21st June 2018

Our Ref CRTR-PLAN-2018-
24963
Your Ref 18/00904/F

Proposal: Formation of inland waterways marina with ancillary facilities building, car parking, access and associated landscaping including the construction of a new lake
Location: Glebe Farm, Boddington Road, Banbury
Waterway: Oxford Canal

Fig 6.20.

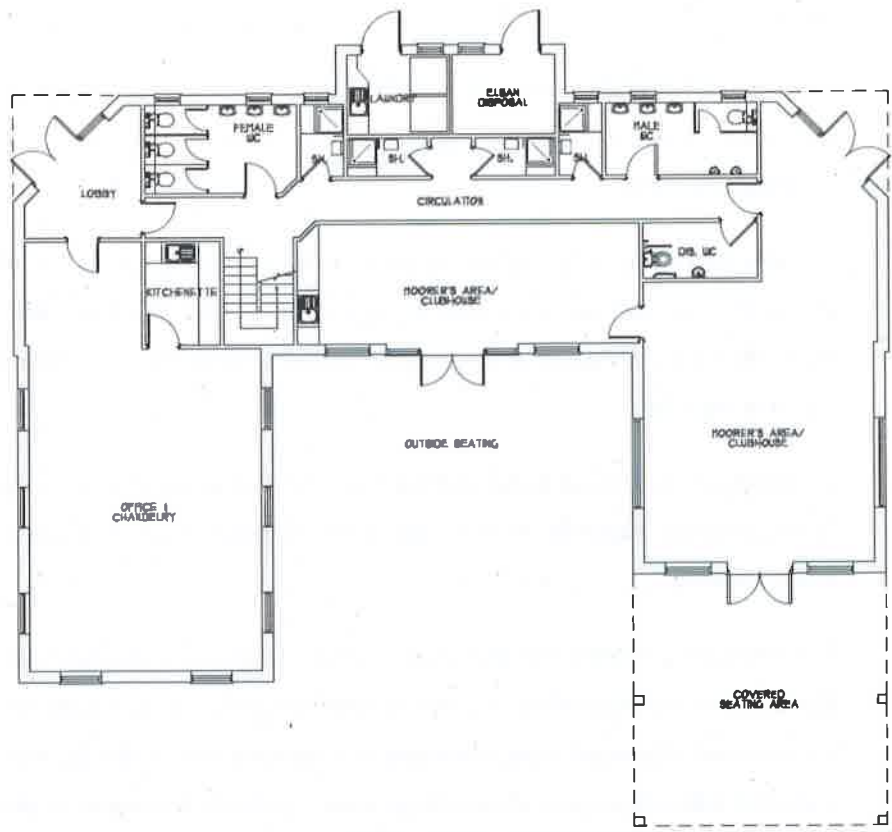
A much simpler, robust form taking cues from agricultural and industrial waterway precedents would be much more appropriate and **amended plans should be submitted for consideration prior to determination** of the current application. The submission indicates that waste storage will be provided within the clubhouse though it is not clear from the submitted floor plan where these will be housed. This should be clarified on any amended plan.

Typical elevation of the proposed new footbridge over the new canal entrance.
(Langton Architecture - April 2018)

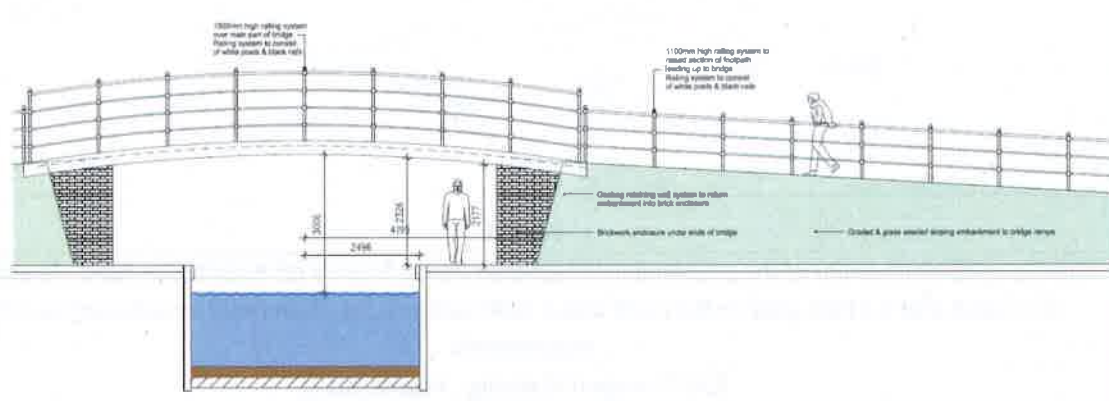
The overall approach to the new bridge design appears to be largely appropriate though the proposed handrail to the bridge should be amended to remove the upstands on the balusters as these could snag tow-ropes. The handrail on the bridge must also tie in seamlessly with that of the approach ramps and not have a step in it.

The submission indicates a store will be included beneath the approach ramp for the storage of stop planks, and the doors to these should be designed to complement the bridge materials and colours. The bridge drawings indicate an epoxy resin bound finish on the metal bridge deck, and it needs to be demonstrated that this is slip proof and durable enough not to become delaminated over time. The ramp to the bridge should also be finished in the same material as the deck, to provide a seamless, high-quality finish. The applicant must take full responsibility for maintenance of the bridge, and the decking finish.

The submission indicates that the 'Geobag' retaining structure to the bridge will be covered by the grass embankment. It is important to ensure that the retaining structure is not to be visible at all and if any sections remain visible these should be finished in brickwork.

Notwithstanding the information indicated on the submitted plans prior to the commencement of any works to the marina entrance from the mainline of the Oxford Canal full details for the marina entrance and towpath bridge shall be submitted to and approved in writing by the Local Planning Authority. These details shall provide for:

- *handrail details to the towpath bridge;*
- *Surface finishes for the towpath bridge and approach ramps;*
- *finishes for the ‘Geobag’ retaining structure;*
- *maintenance and management regimes for the marina entrance and towpath bridge.*
